## RE: 31 Fore St- submissions to meet conditions

**Subject:** 31 Fore St- submissions to meet conditions

This project was approved in March and the attached plans (also in e-plan- I had previously uploaded them but put them in the BP file rather than the SP file) were submitted last week to address the following conditions of approval:

DRAWING NAME: **SITE PLAN**
 PROJECT NAME: **31 FORE STREET REDEVELOPMENT**
 CLIENT: **PENINSULA PROPERTY DEVELOPMENT, LLC.**
 ADDRESS: 59 MOODY STREET, PORTLAND, MAINE 04101

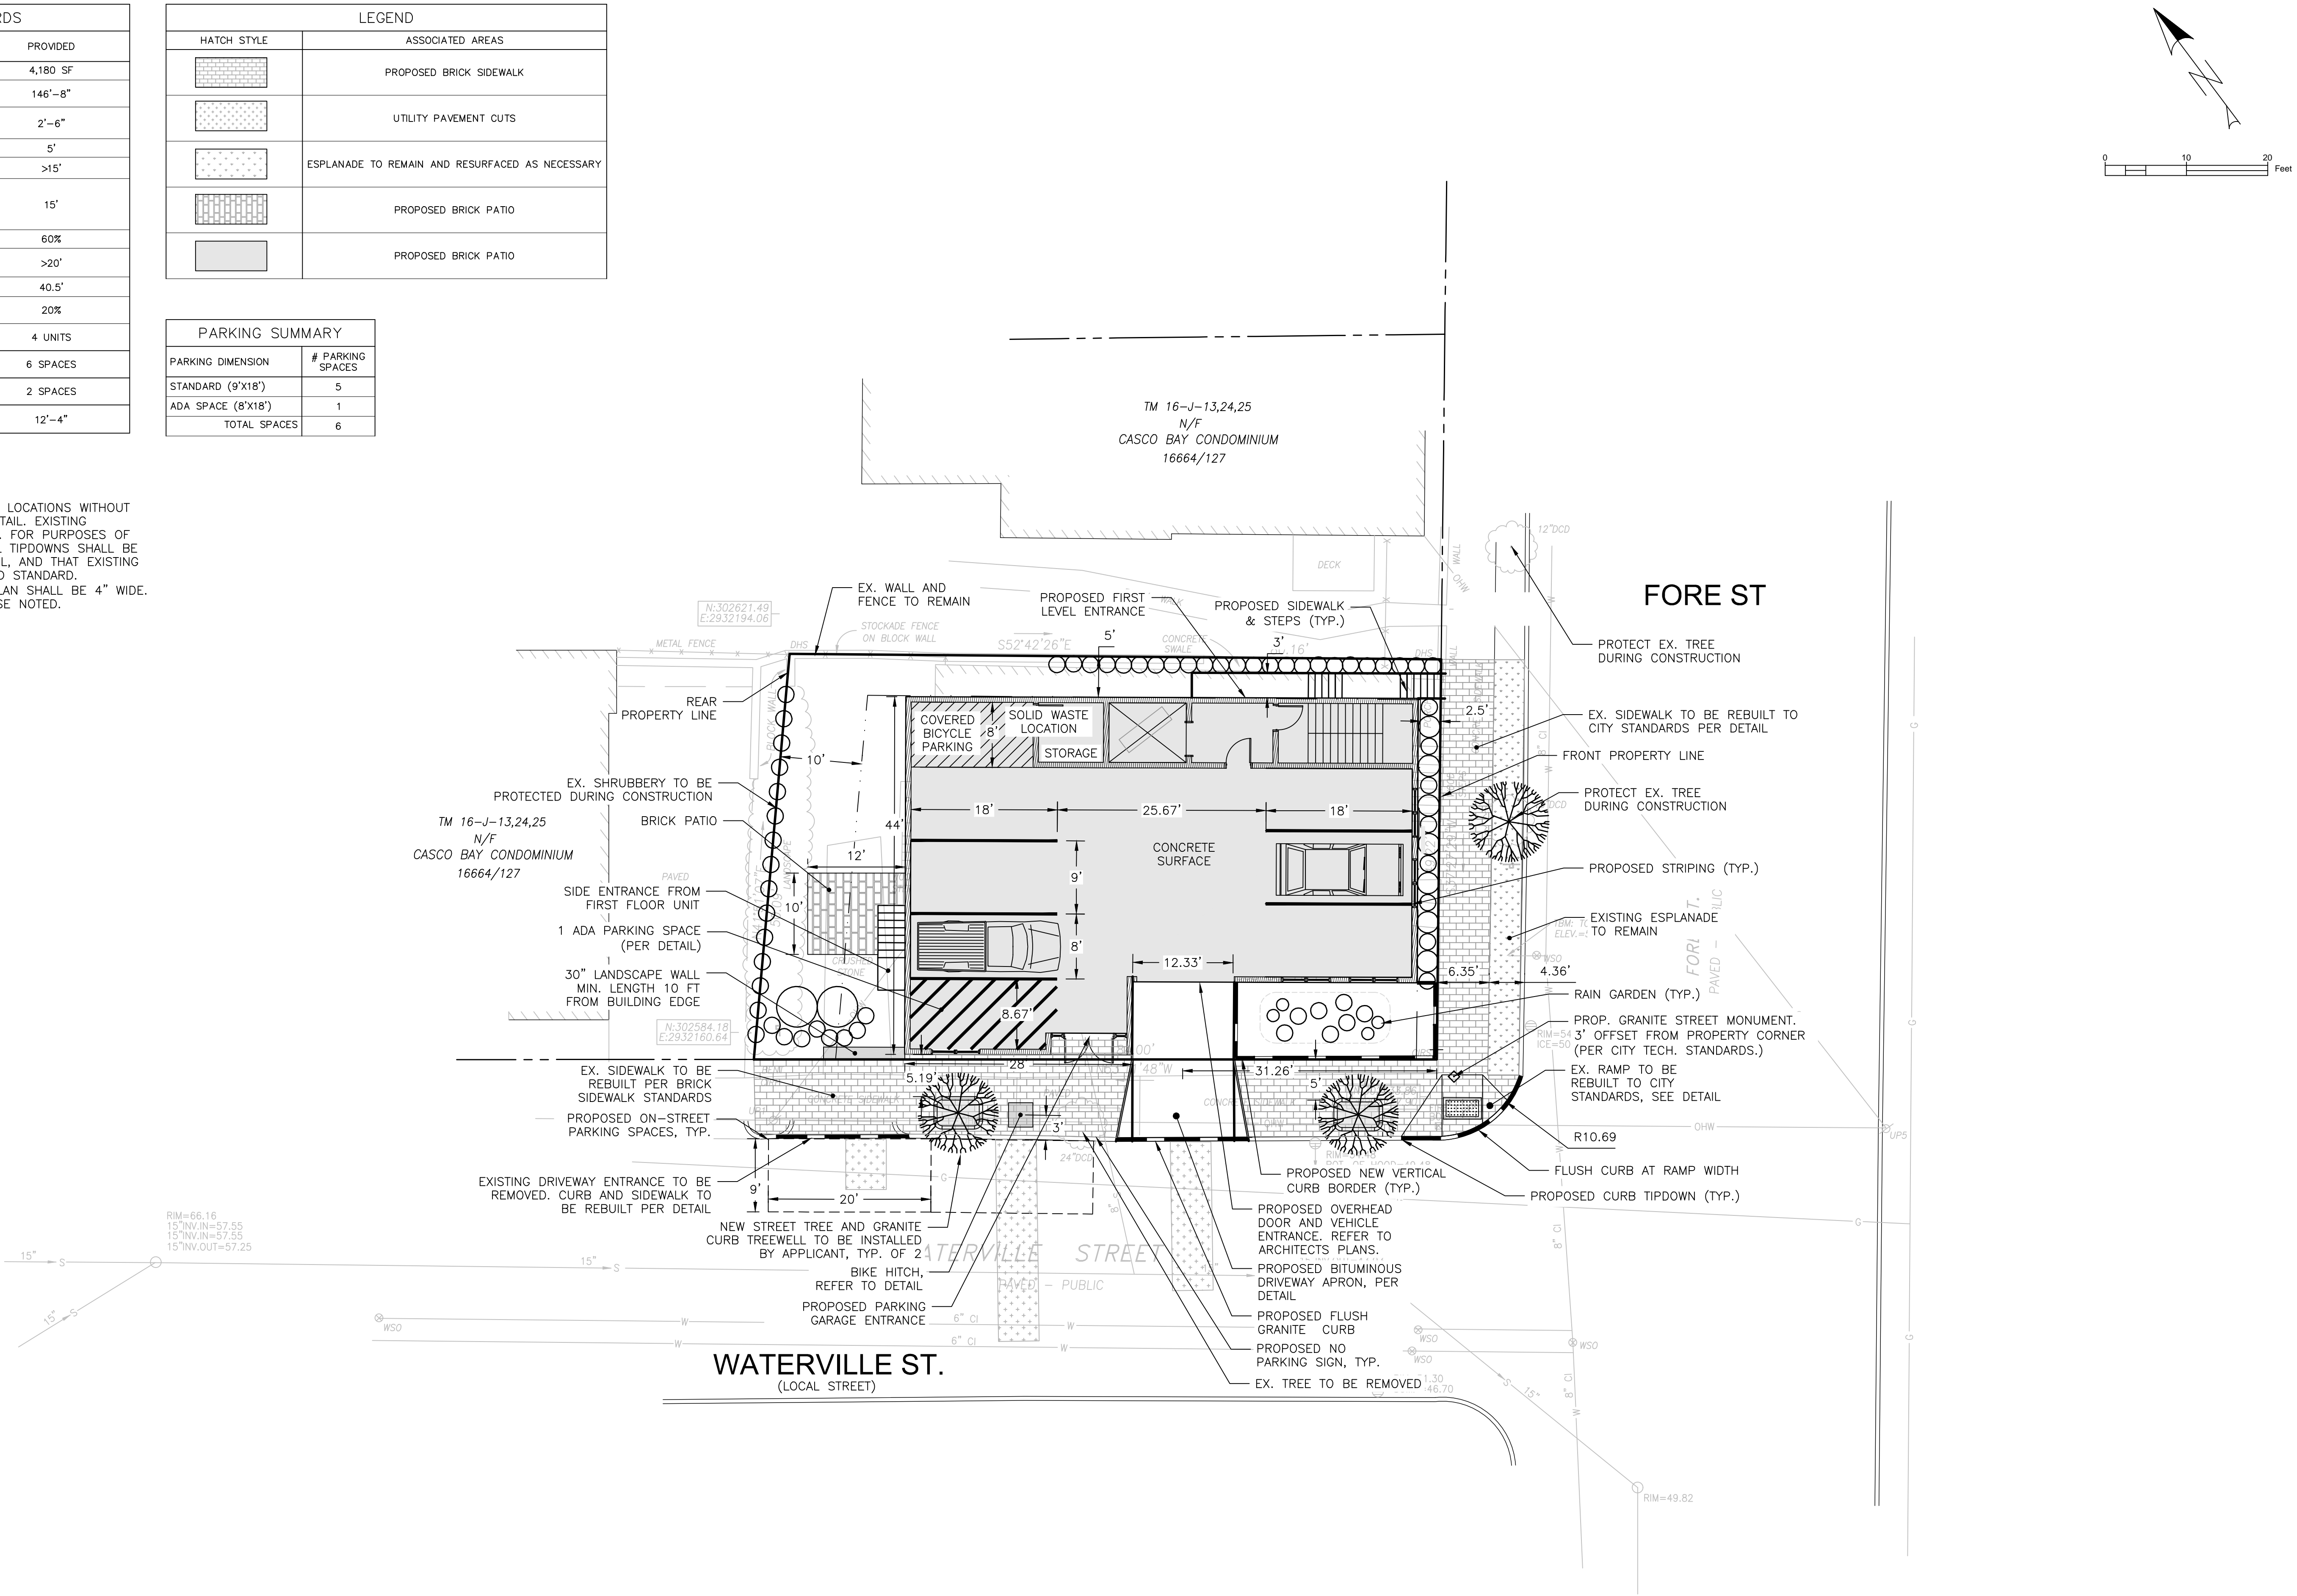
Our only remaining comment was with regards to the backflow preventer. In the last iteration it was located in the right of way. It is now located right on the right of way line, but the plan note still says that it's located within the City's right of way. They have added a concrete collar to help protect it as it's located in the driveway, so I don't have an issue with a location. Dave, let me know what you think from the City's perspective, and I can make sure our comments match up.
